Connah's Quay Low Carbon Power

Draft Statement of Common Ground between Uniper UK Limited and Natural Resources Wales (Tracked)

Document Reference: EN010166/APP/8.2

Revision 04

Plate 1: Saltmarsh Creation Area (Outline Landscape and Ecology Management Plan (EN010166/APP/6.9))

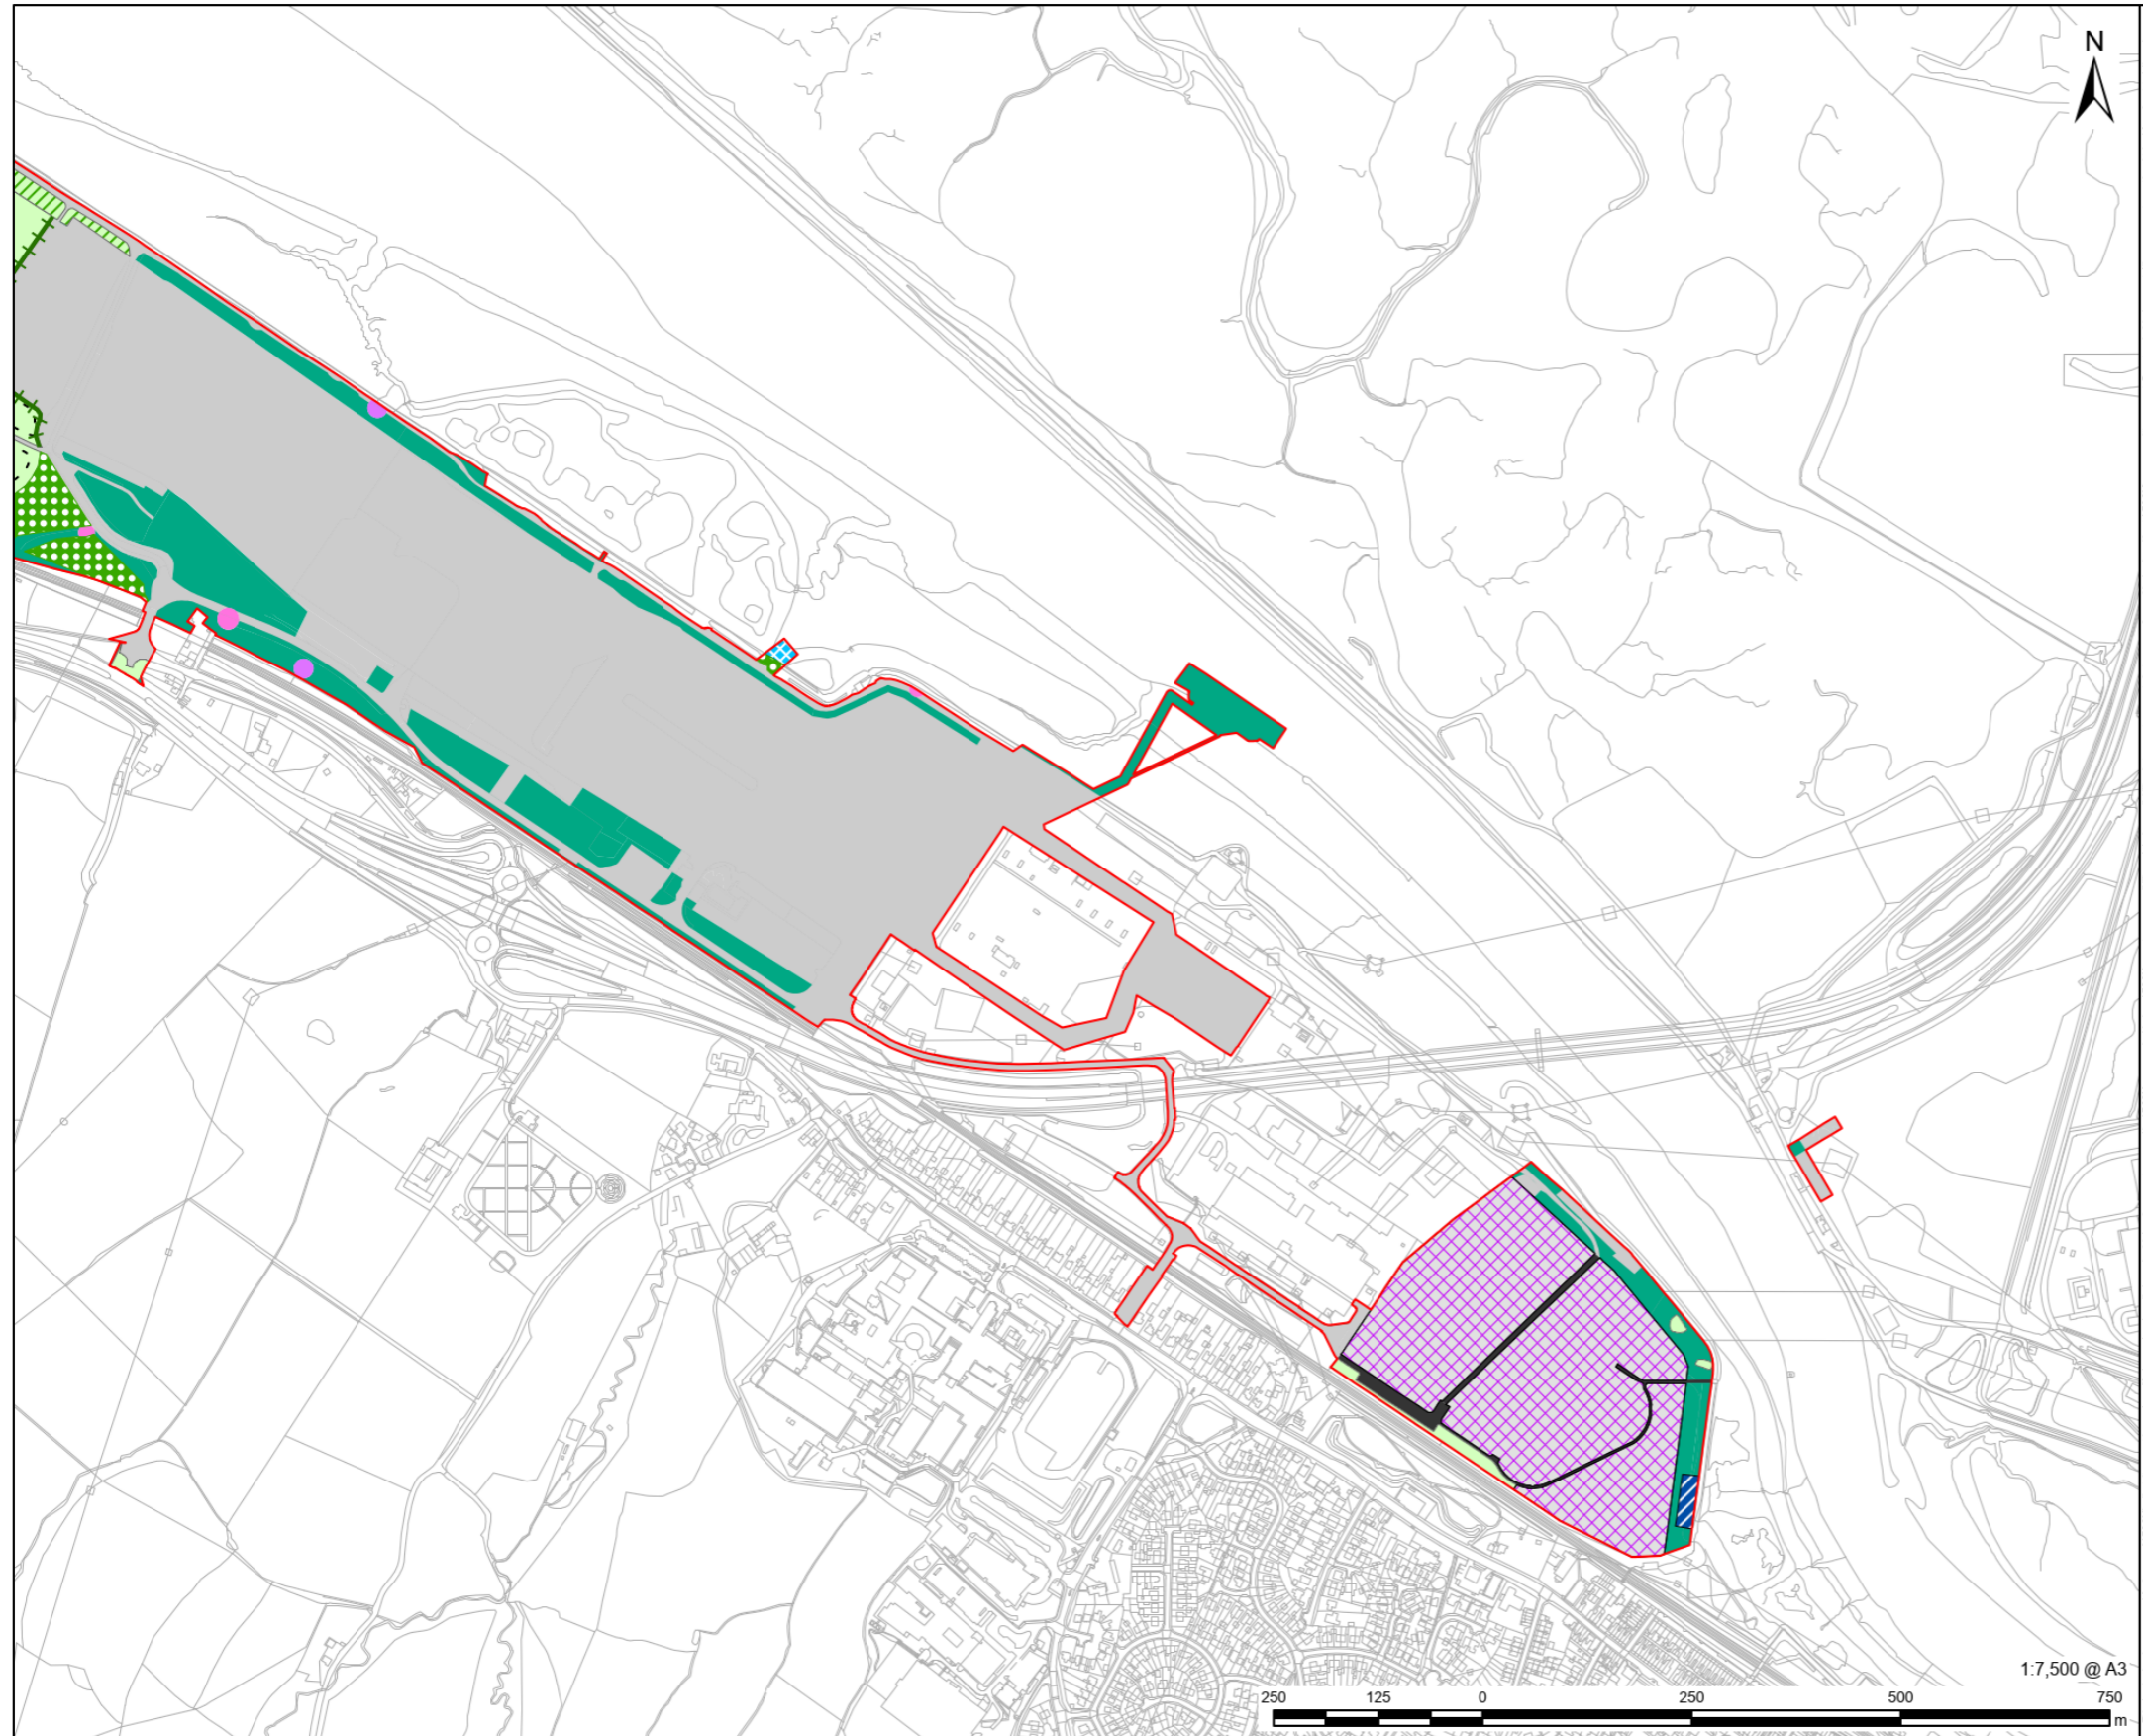
Ref	Topic	Relevant Application Document	Summary of NRW Comment within their Written Representation [REP1-073]	Applicant's position at D2 Submission [REP3-057]	Deadline 45 Commentary	Status	Likelihood of Resolution
			at compensating for the loss of area and quality of the same habitat type on a protected site, even where the new area will be bigger and of higher quality, are highly difficult to forecast with any degree of certainty and, in any event, will be visible only several years into the future...". Therefore, following the reasoning within the Briels judgment, although, in principle, a measure of utilising replacement land may be considered mitigation in certain limited circumstances, if, in fact, its effectiveness, in terms of ensuring that there will be no adverse effect on the integrity of the site, is not beyond scientific doubt at the point of assessment, then it should be considered as a compensatory measure rather than mitigation. Further, R. (on the application of Lee Valley Regional Park Authority) v Epping Forest DC [2015] EWHC 1571 (Admin), which references the judgement in Briels, highlighted that the creation of alternative habitat to offset loss within a protected site should be treated as compensation rather than mitigation. The fact that the Applicant references other DCO's or local authorities which have treated replacement habitats as mitigation, does not by itself change the legal position as set out above and should not be relied upon to avoid an adverse assessment under Article 6(3) as each DCO application is fact specific and would be considered on its own merits. We therefore acknowledge that such proposals, in principle and in very limited circumstances, could potentially be considered as mitigation for HRA purposes but consider that this would be subject to their effectiveness proving, at the point of assessment, that it is beyond scientific doubt there will be no adverse effect on the SAC. However, it is not currently clear whether this would be the case.

Ref	Topic	Relevant Application Document	Summary of NRW Comment within their Written Representation [REP1-073]	Applicant's position at D2 Submission [REP3-057]	Deadline 45 Commentary	Status	Likelihood of Resolution
			maintain it in favourable condition, the achievement of which includes the following condition being met: the total extent of Atlantic salt meadow vegetation communities within the site is maintained. Although the area of saltmarsh habitat which would be permanently lost to the development is low, there would still be a net loss of this Annex I habitat type. The Applicant proposes offsetting this by enabling managed retreat of the embankment between the power station and Dee Estuary SAC/SPA/Ramsar site/SSSI to create an approximately 1,300m² area for natural migration inland of the saltmarsh, which we consider to be a sufficient area to offset these losses, in principle. We note that the applicant considers this would 'offset' the impact on saltmarsh rather than represent 'compensation' in the context of the Habitats Regulations and considers it as mitigation for HRA purposes. However, the proposed area of new saltmarsh would be located outside of the SAC and hence lack its standard of statutory protection. We have considered case law relating to this matter and offer the following advice. In the European case of T.C Briels and Others v Minister van Infrastructuur en Milieu (C-521/12) the CJEU considered whether a measure for the creation of an area equal to, or greater than the habitat to be lost would be considered as mitigation or compensation. In that judgement it was determined that "the assessment carried out under Article 6(3) of the Habitats Directive cannot have lacunae and must contain complete, precise and definitive findings and conclusions capable of removing all scientific doubt as to the effects of the works proposed on the protected site concerned". This judgement also noted that "as a rule, any positive effects of a future creation of a new habitat which is aimed	A saltmarsh creation strategy is being produced which will take into account the advice given in paragraphs 2.1.40 to 2.1.42 of the Written Representation. Note that it was always the intention to lower the ground level in order to create a suitable area for the saltmarsh to retreat into. With regard to whether the newly created saltmarsh would suffer from the significant adverse atmospheric impacts predicted elsewhere in the Dee Estuary (see NRW Key Concern 1), please see the Applicant's Response to Relevant Representations [REP1-062], Ref. No. NRW4. The area of saltmarsh being identified for mitigation would enable an entire area of saltmarsh 200 times larger than the area to be permanently lost to persist that would otherwise be lost to coastal squeeze. This will be true even though the 0.13 ha area will also be subjected to atmospheric nitrogen deposition. The Applicant has addressed points raised in 2.1.44 in the Applicant's Response to Relevant Representations [REP1-062], Ref. No. NRW7.	<u>Creation Strategy</u> <u>(EN010166/APP/9.16).</u>
